**Planning Department
Transportation Development Services**

**Re: Parking Expansion for Dr. Haltom
10433 Lagrima De Oro
Traffic Circulation Layout
Engineer's/Architect's Stamp dated 7-28-15 (F21-D052)**

Based upon the information provided in your submittal received 7-28-15, the above referenced plan cannot be approved for Building Permit until the following comments are addressed:

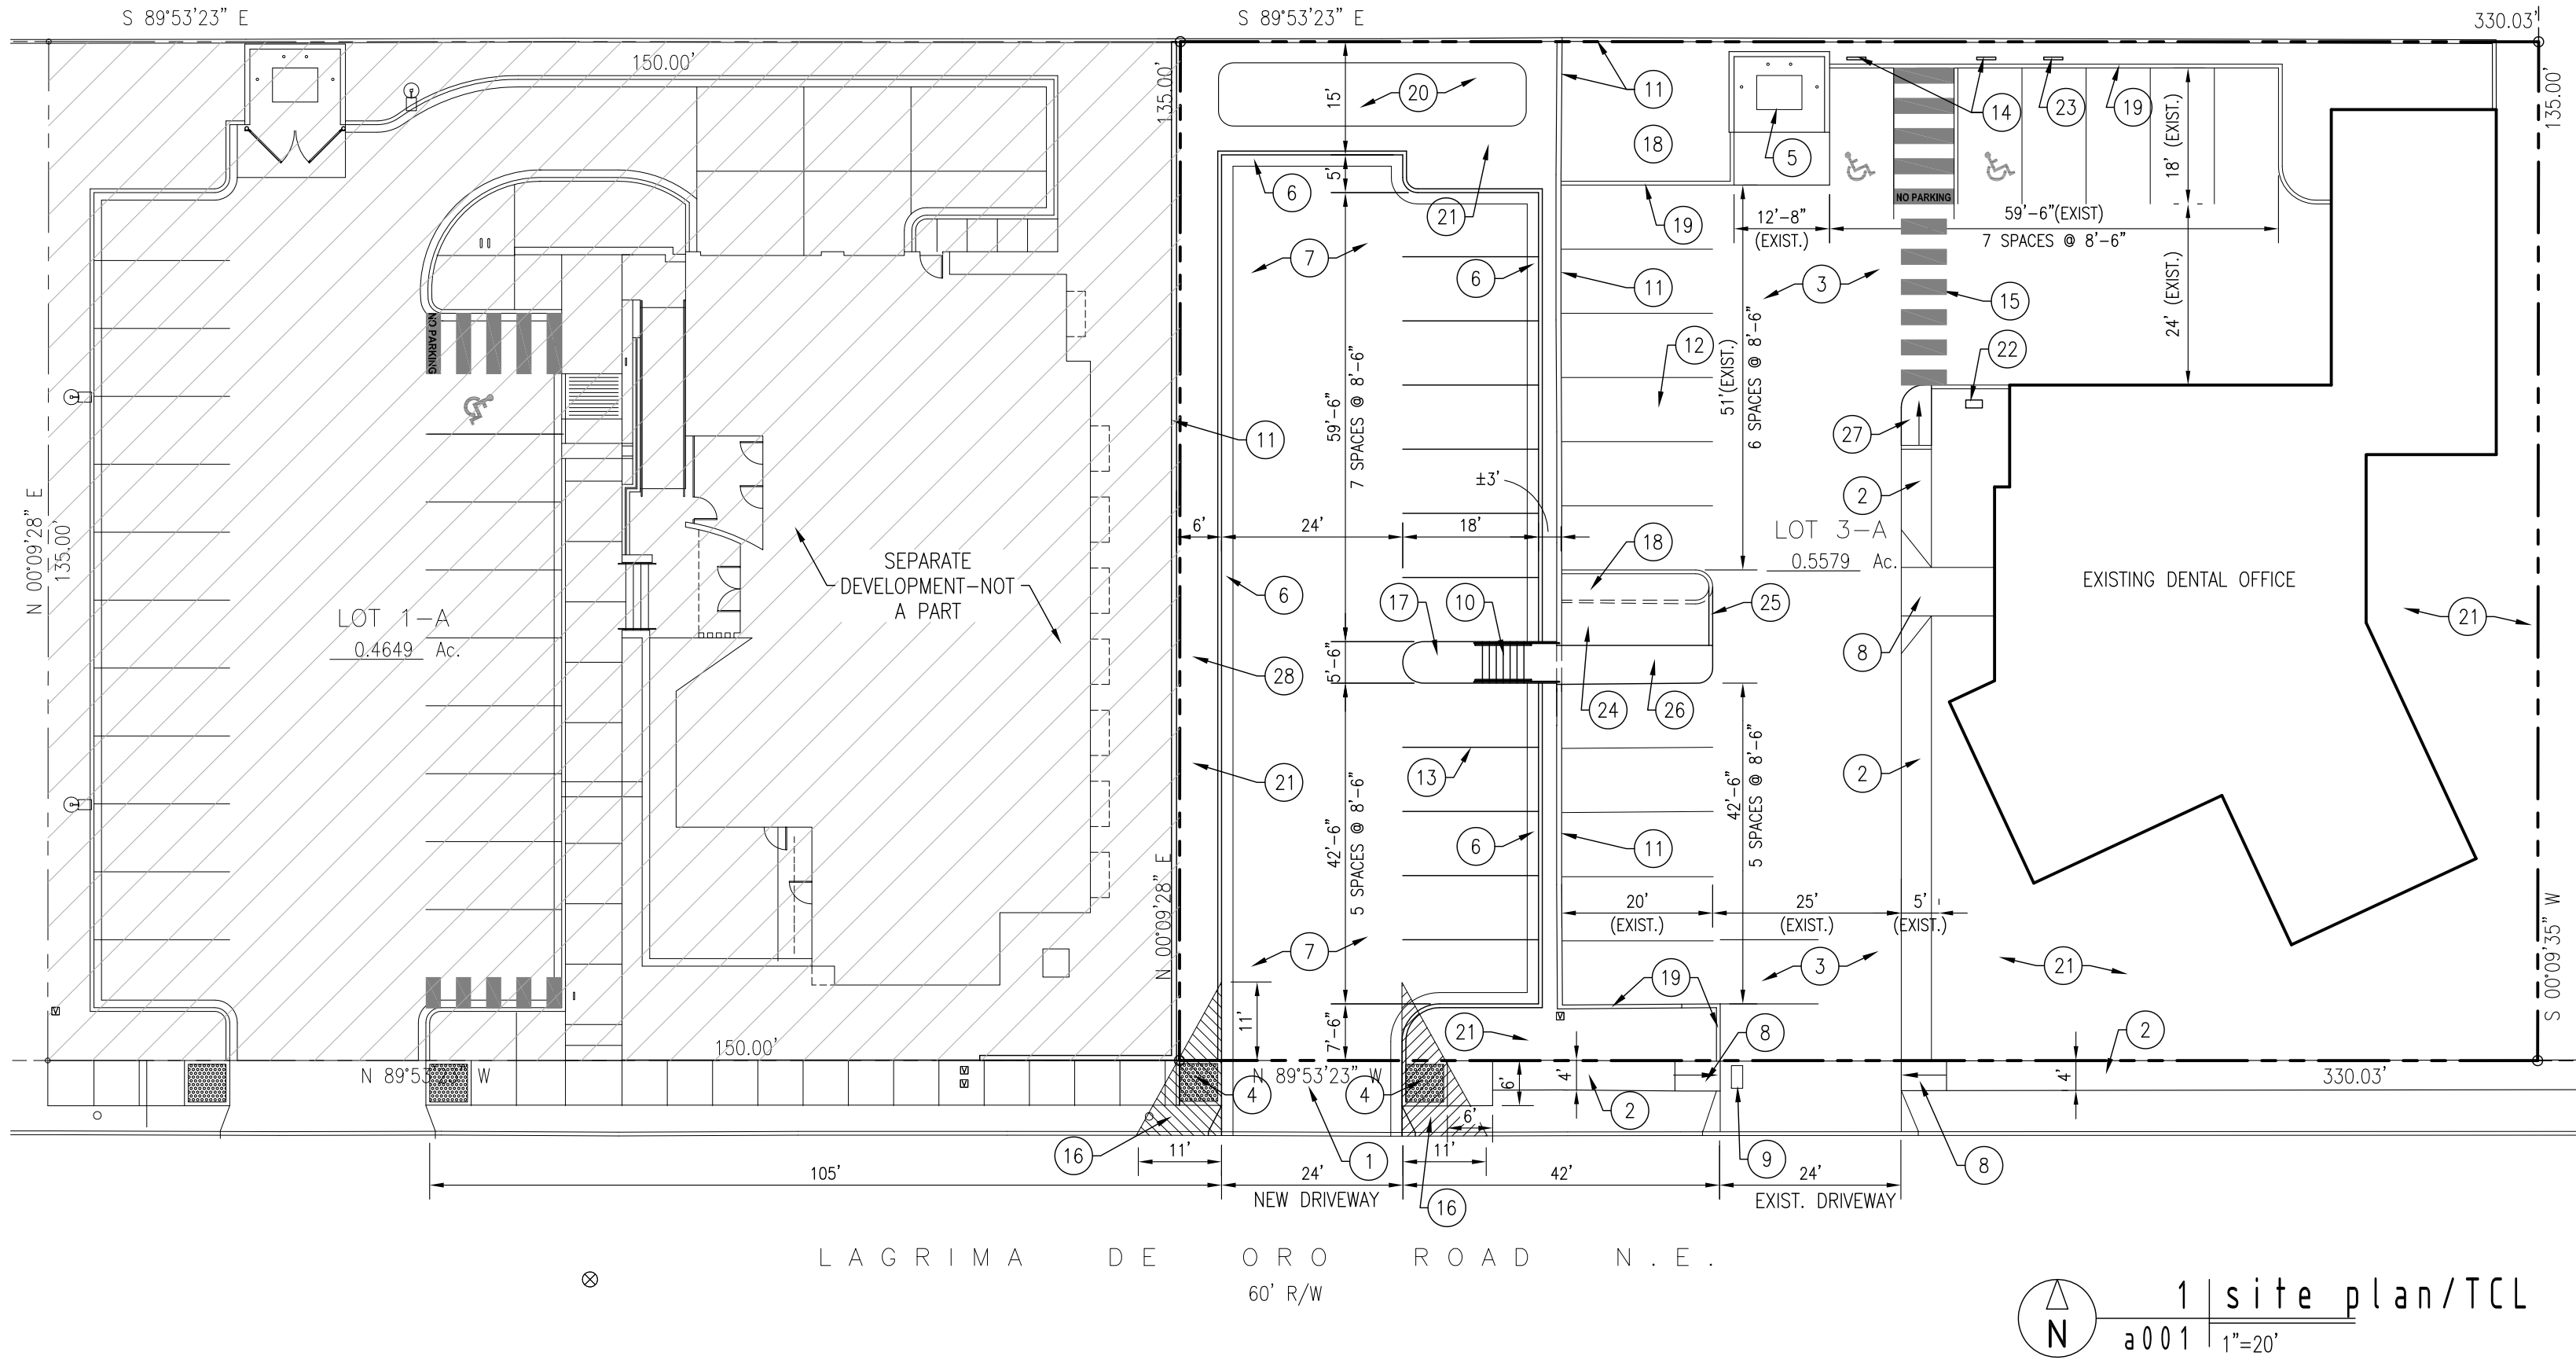
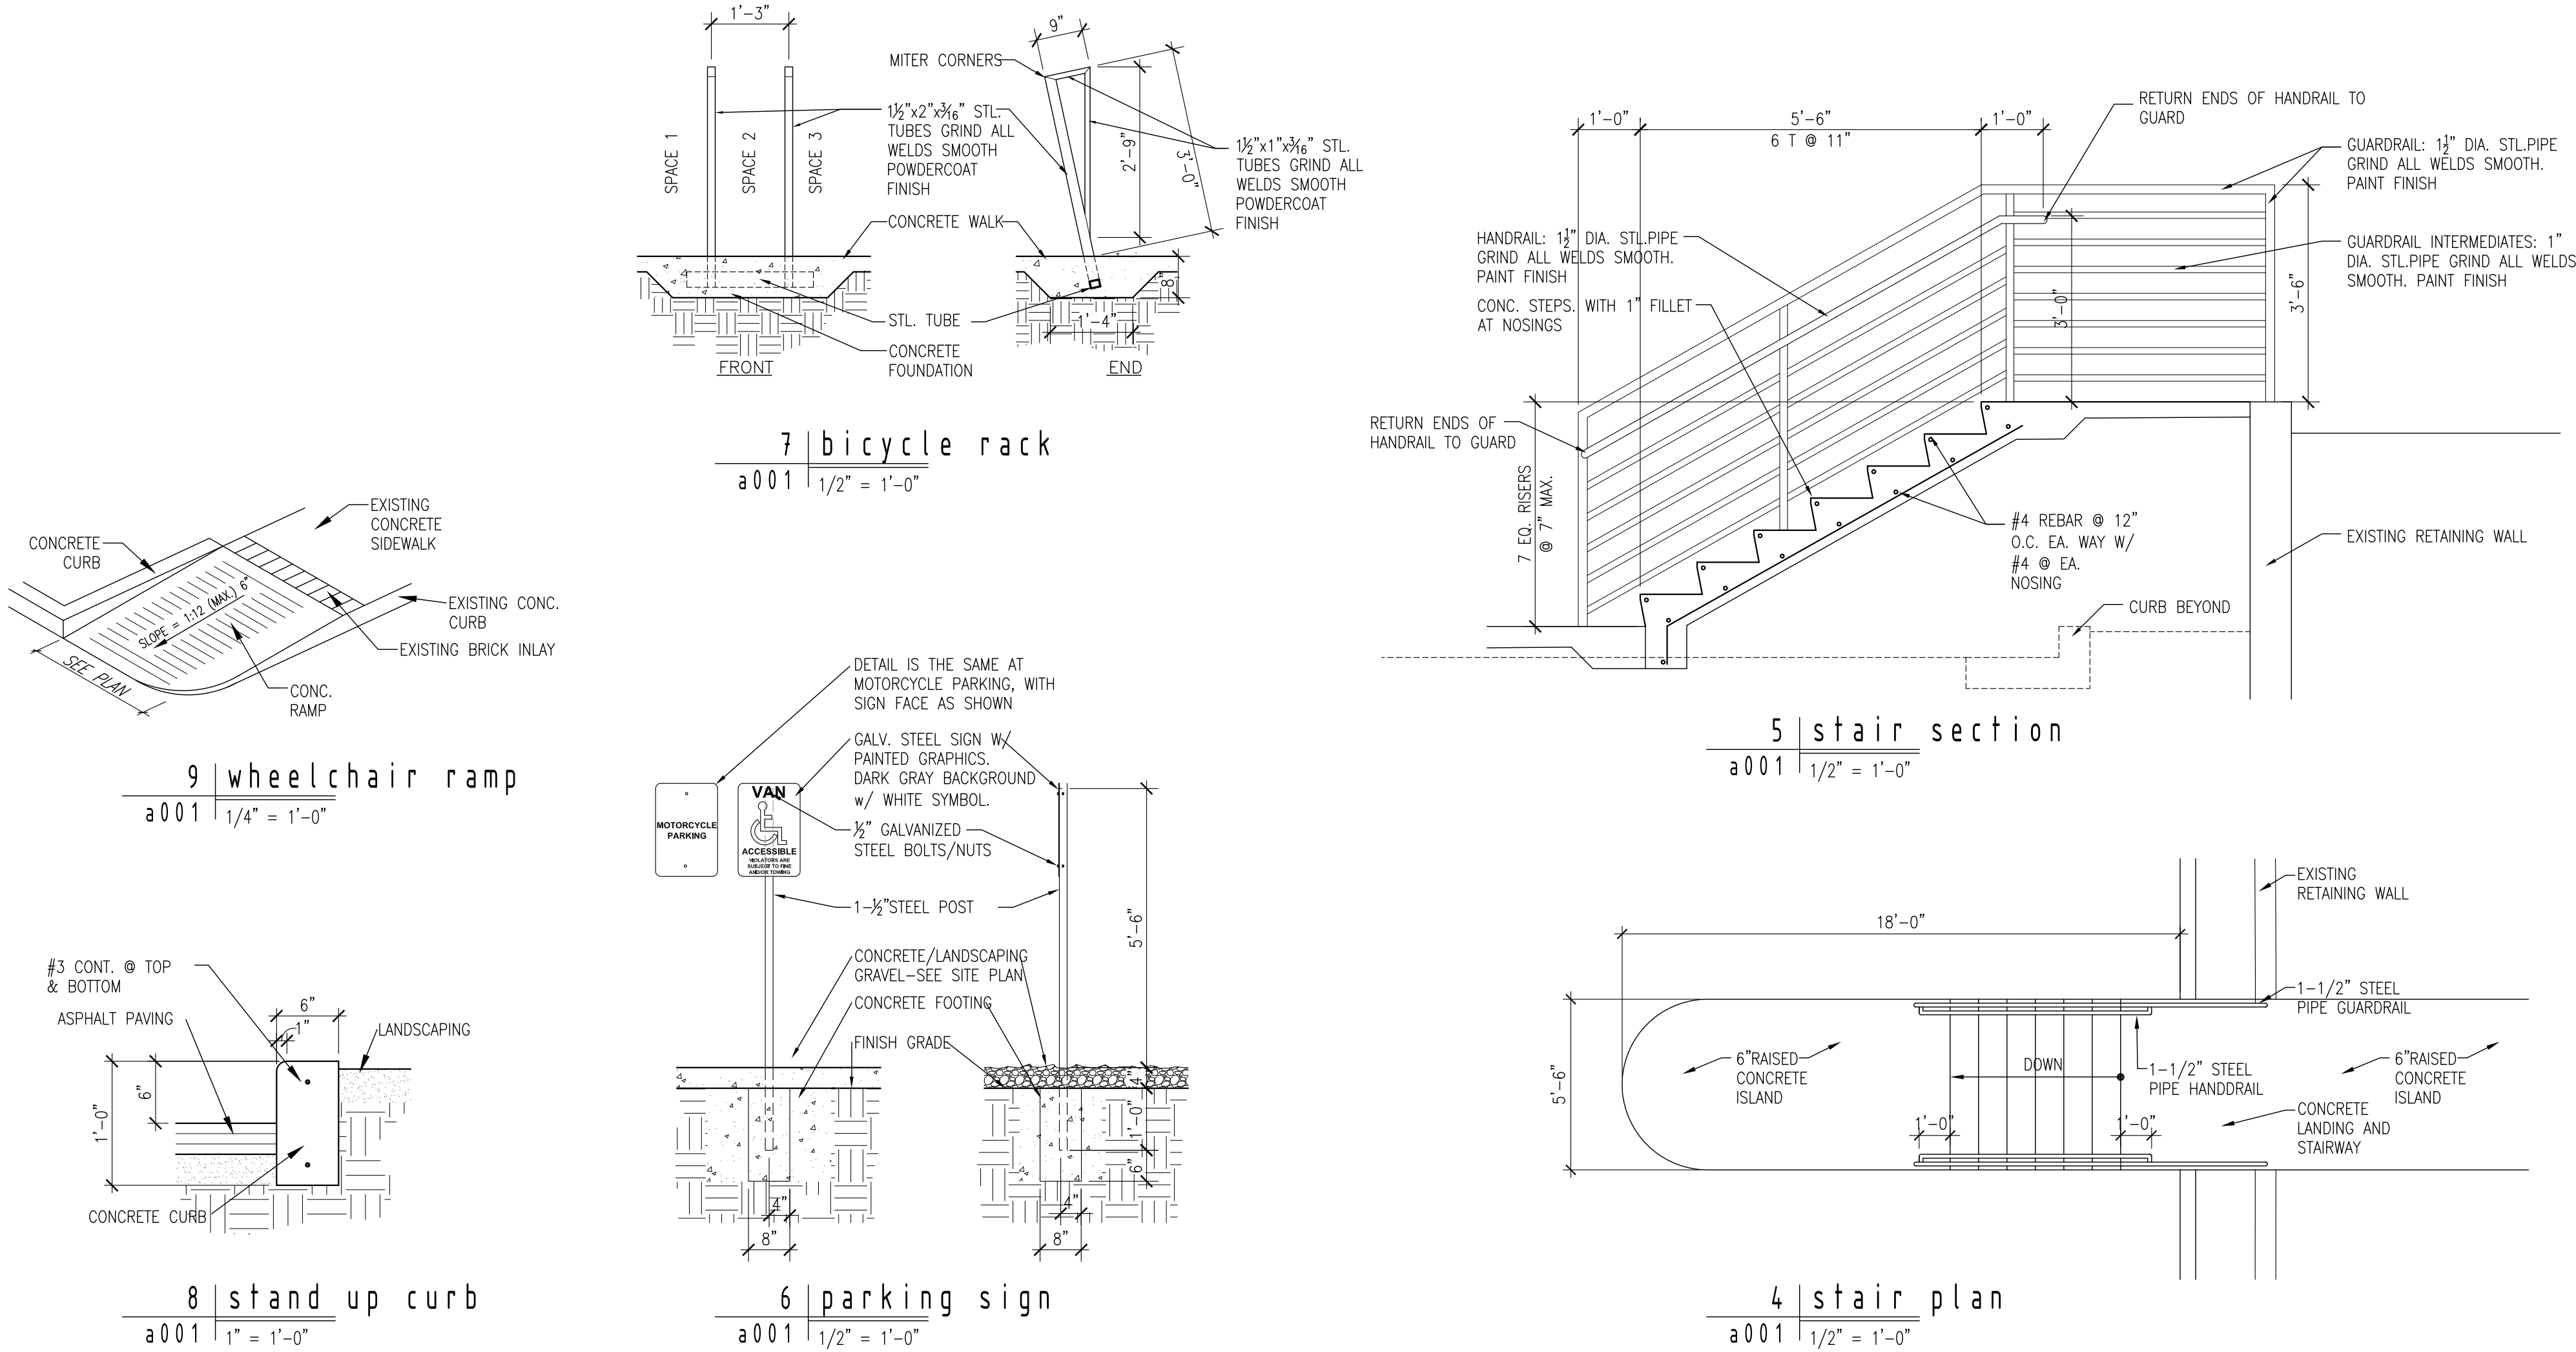
1. Clarify the extents of the development to the west of the existing building. Please detail property lines. If parcels have been re-platted, please provide documentation of platting action.
2. Due to the increase in parking spaces, an additional Handicap parking space will be required. Removal of the island south of the existing marked pedestrian walkway can accommodate the additional ADA parking space.
3. Please include a copy of your shared access agreement with the adjacent property owner, if applicable.
4. Please include two copies of the traffic circulation layout at the next submittal.
